**RESPONSE TO REVIEW COMMENTS**

**BUILDING REVIEW**

**October 16, 2023**

**RE: 2306-124**

Sheet No. **3.0**
 Project No. 2222
 Date: 6/7/23

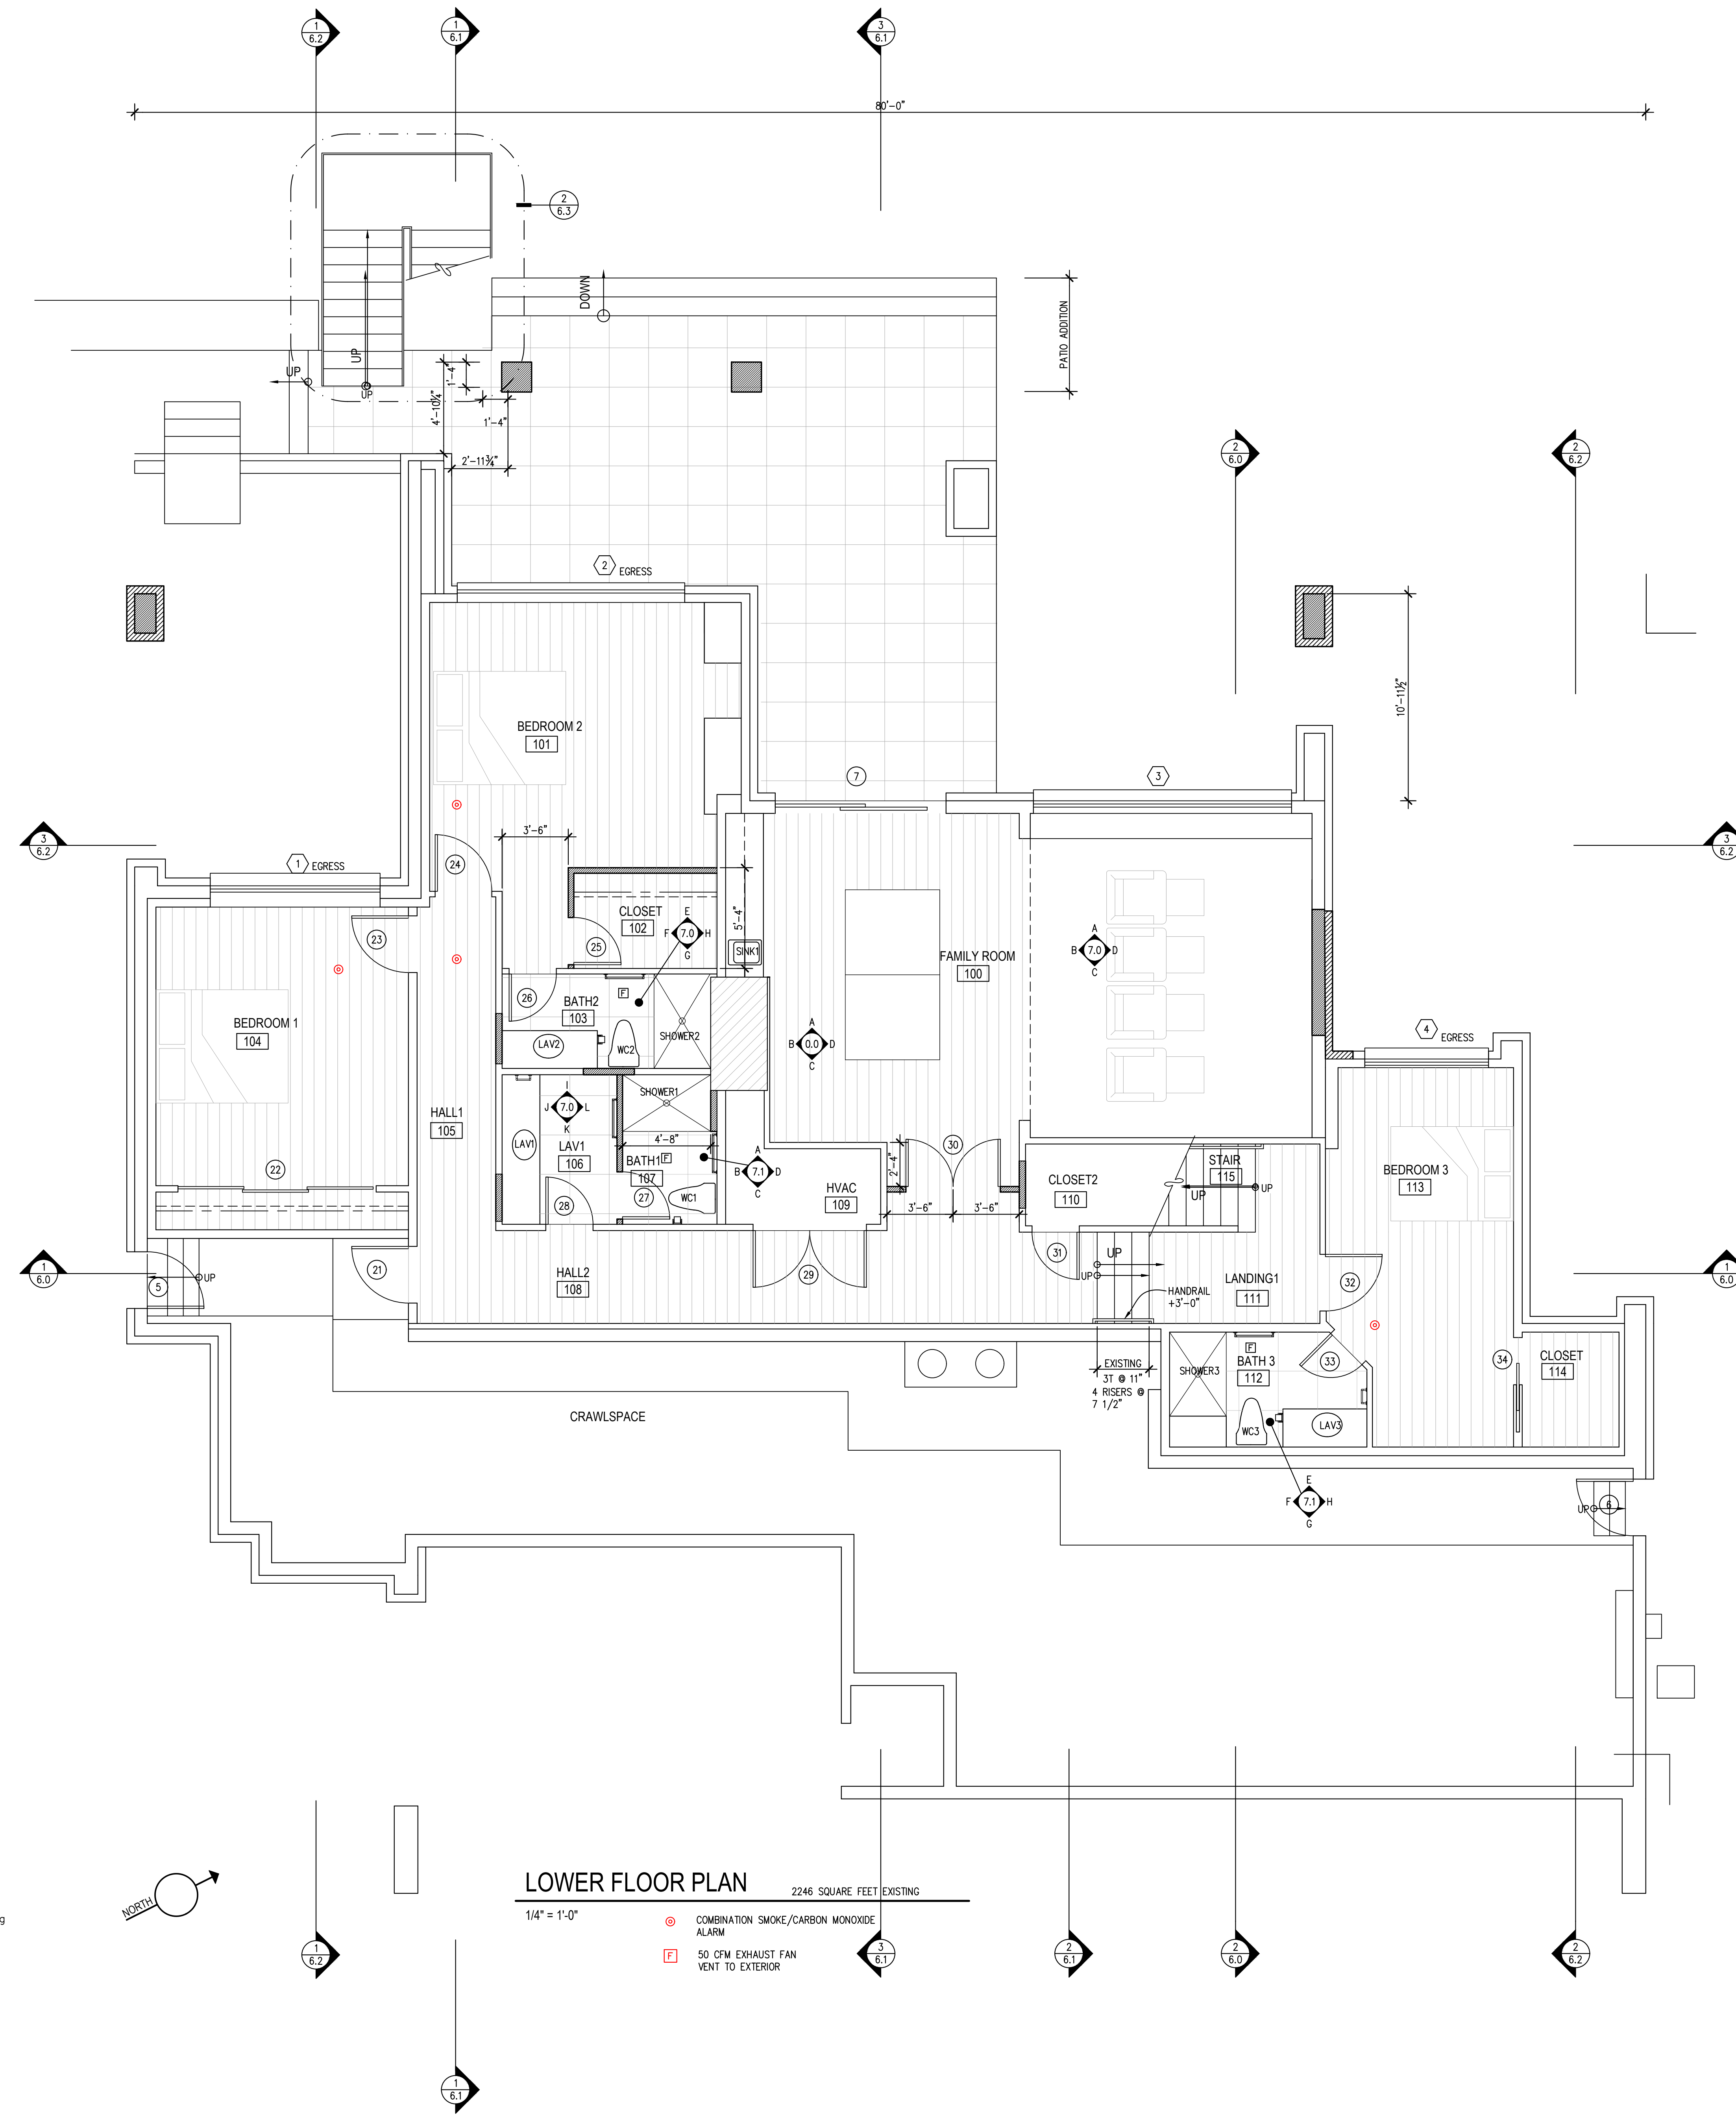
1. Bookmarks added.
2. a. Floor areas of each level are shown on floor plans 3.0, 3.1 and 3.2. Heated, non-heated, garage and deck areas area also shown. Note that there is no definition of floor area in IRC-202.  
b. Floor areas shown  
c. Sheet 1.1 added to illustrate floor areas.
3. A 'D' was added to DADU sheet numbers, the city required us to separate the DADU into a separate permit application.
4. Code references updated. DADU notes added to D2.2.
5. Areas of addition are shown with a hatch pattern. All site walls area existing and will remain.
6. DADU dimensions added.
7. Grids show on the plans now.

ROOF PLAN
1/4" = 1'-0"

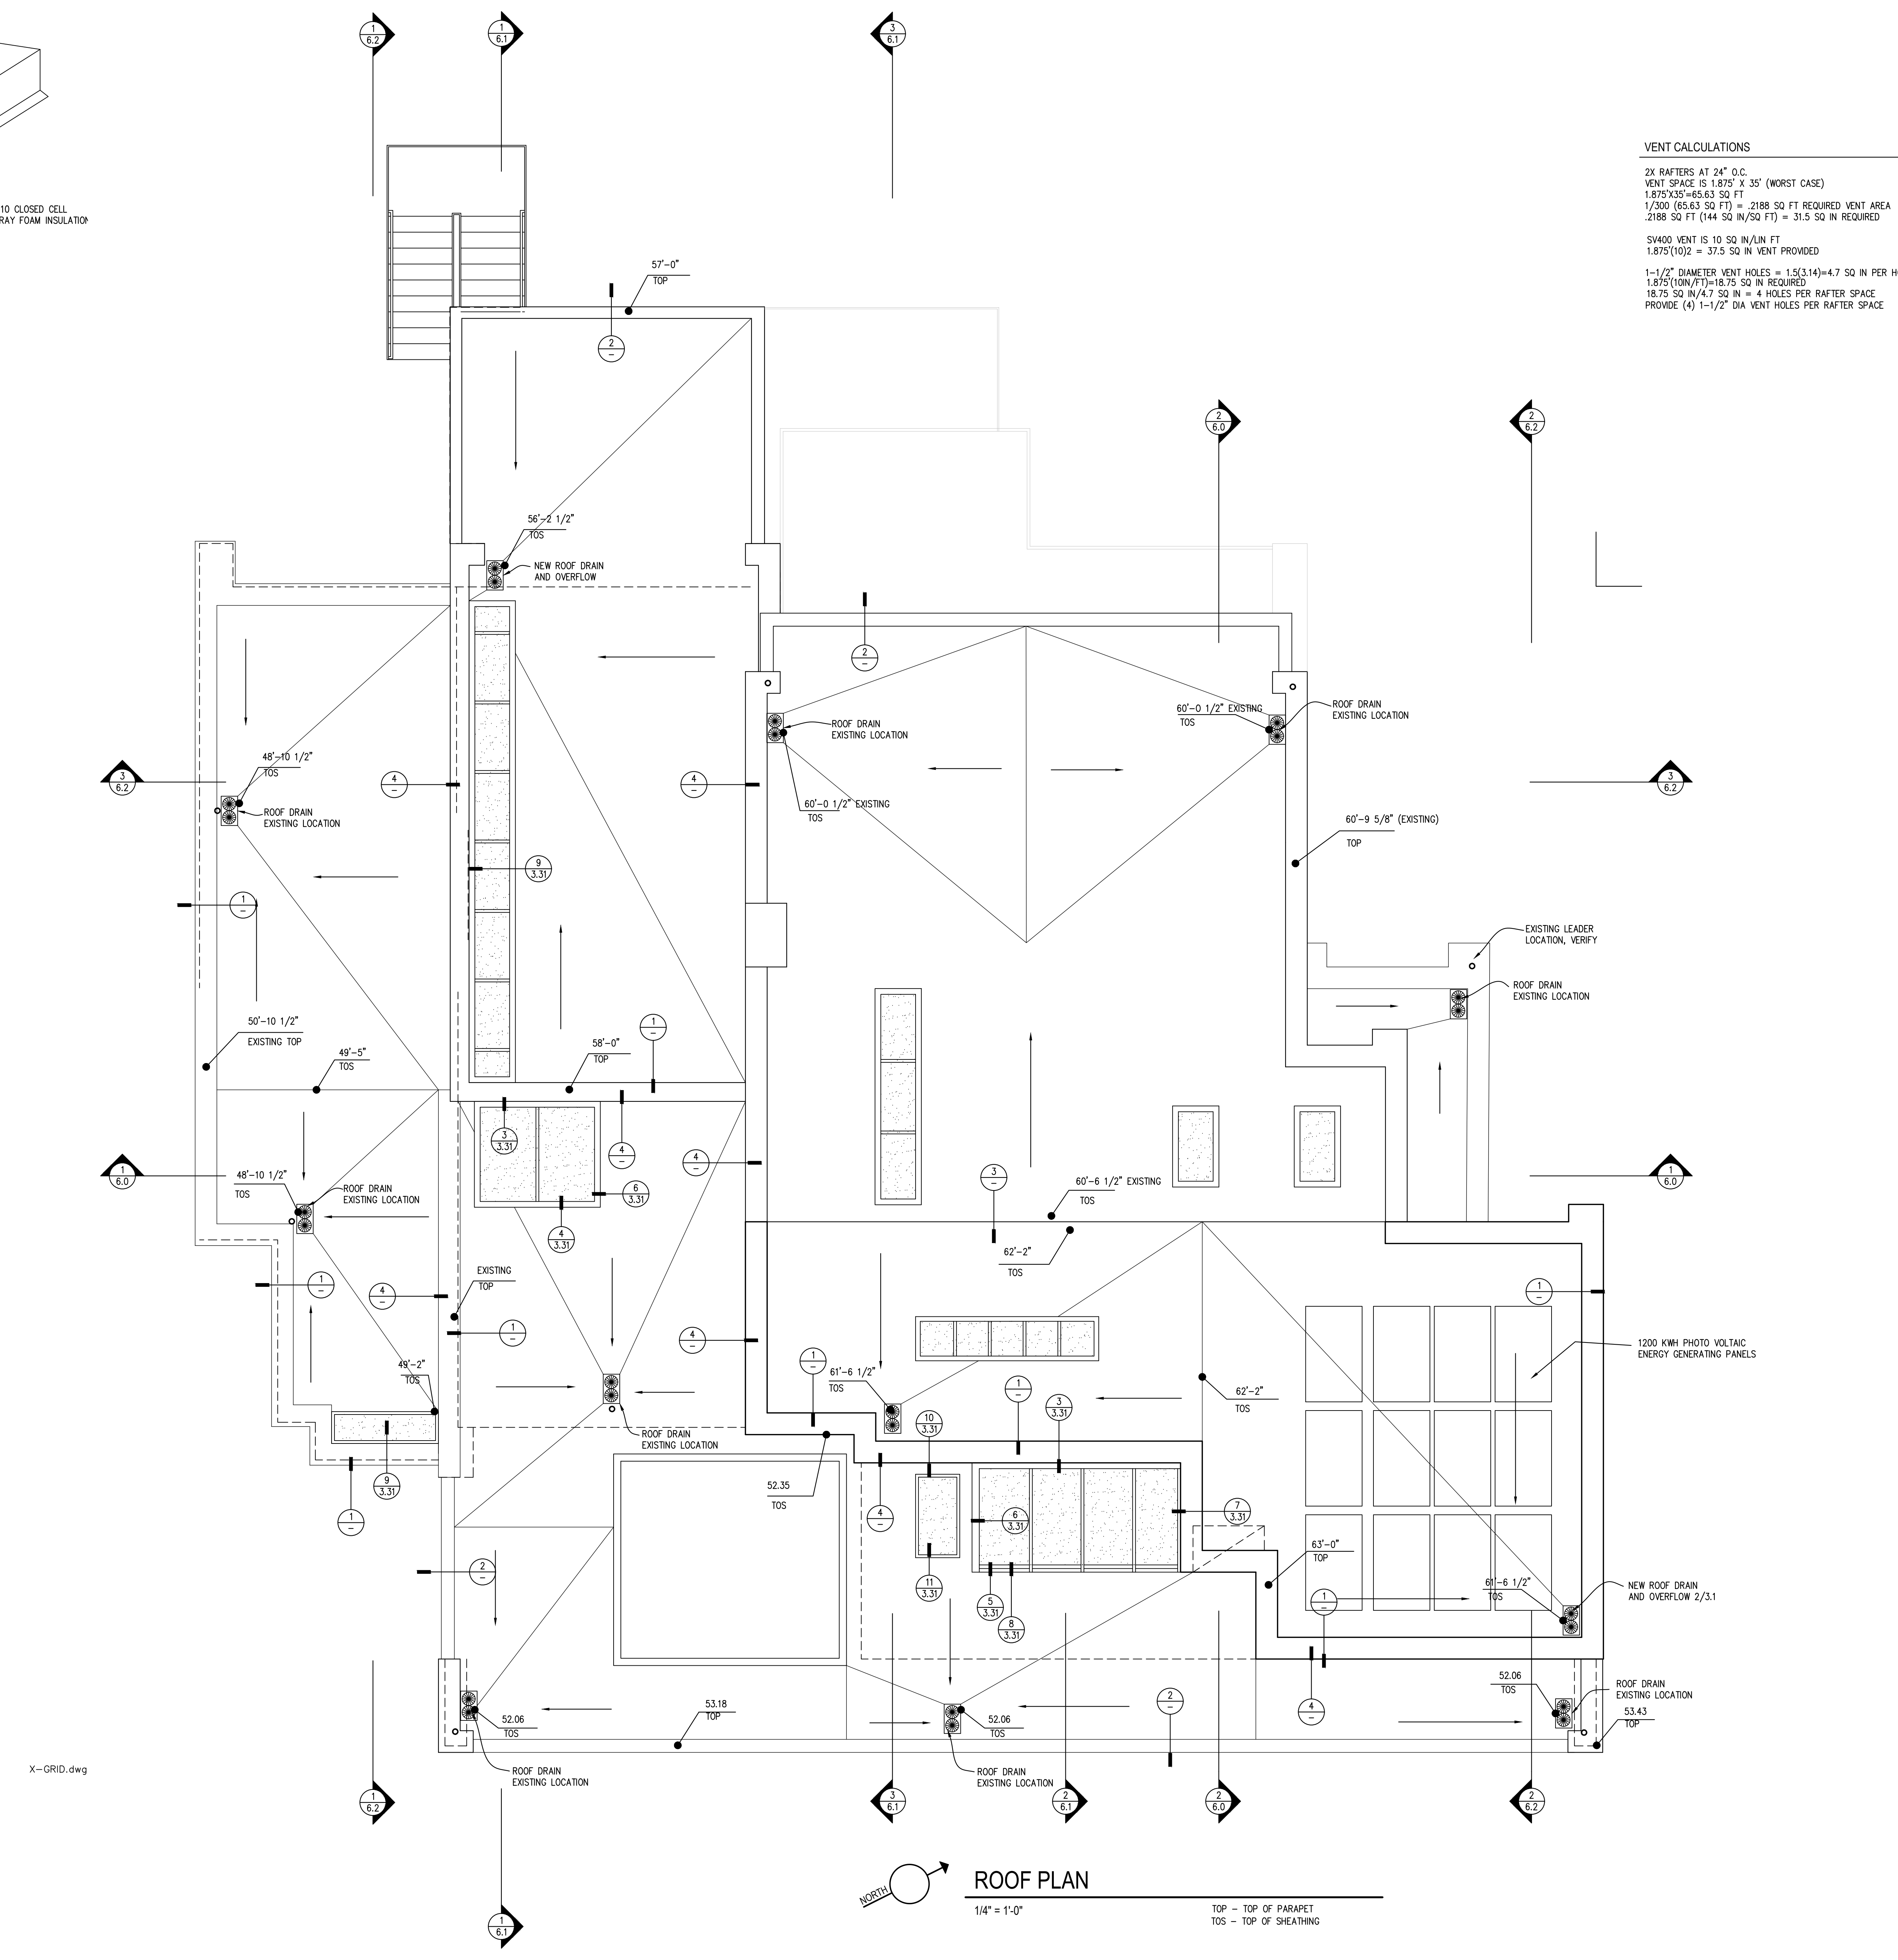
7. a. A roof demolition plan sheet 2.3 has been added.  
b. The roof slopes 1/4" per foot, top of sheathing elevations are noted at high points and roof drains on sheet 3.3, the roof plan. The roofing is specified on sheet 9.0 section 7531.

c. Gravel roof area is shown on sheet 3.3. Pavers are listed on the finish schedule for the deck areas and noted on the building sections.  
d. Skylight glazing noted on sheet 3.3

VENT CALCULATIONS

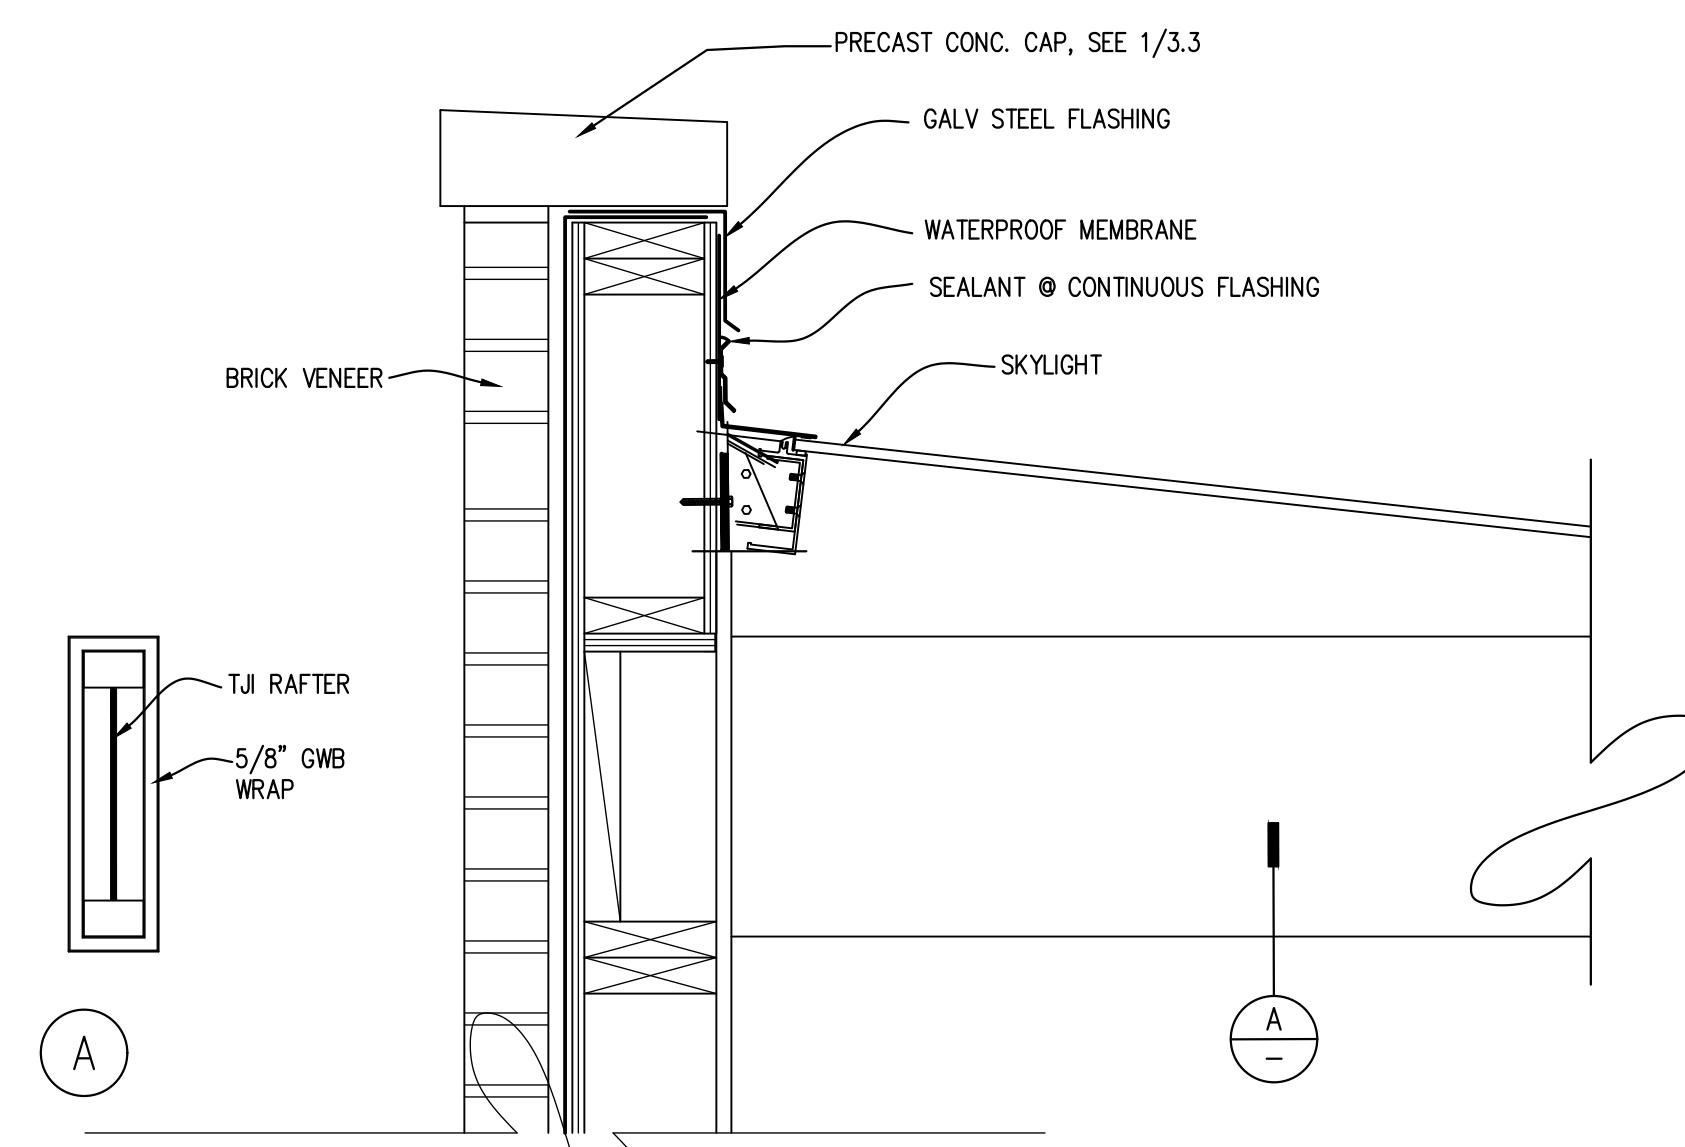
- h. Roof is unvented now, calculations removed.
- 8. Guards are dimension on 5.0, 6.0, and attachment details on 6.4
  - a. Door 8 has been deleted, a window, #15, will replace it.
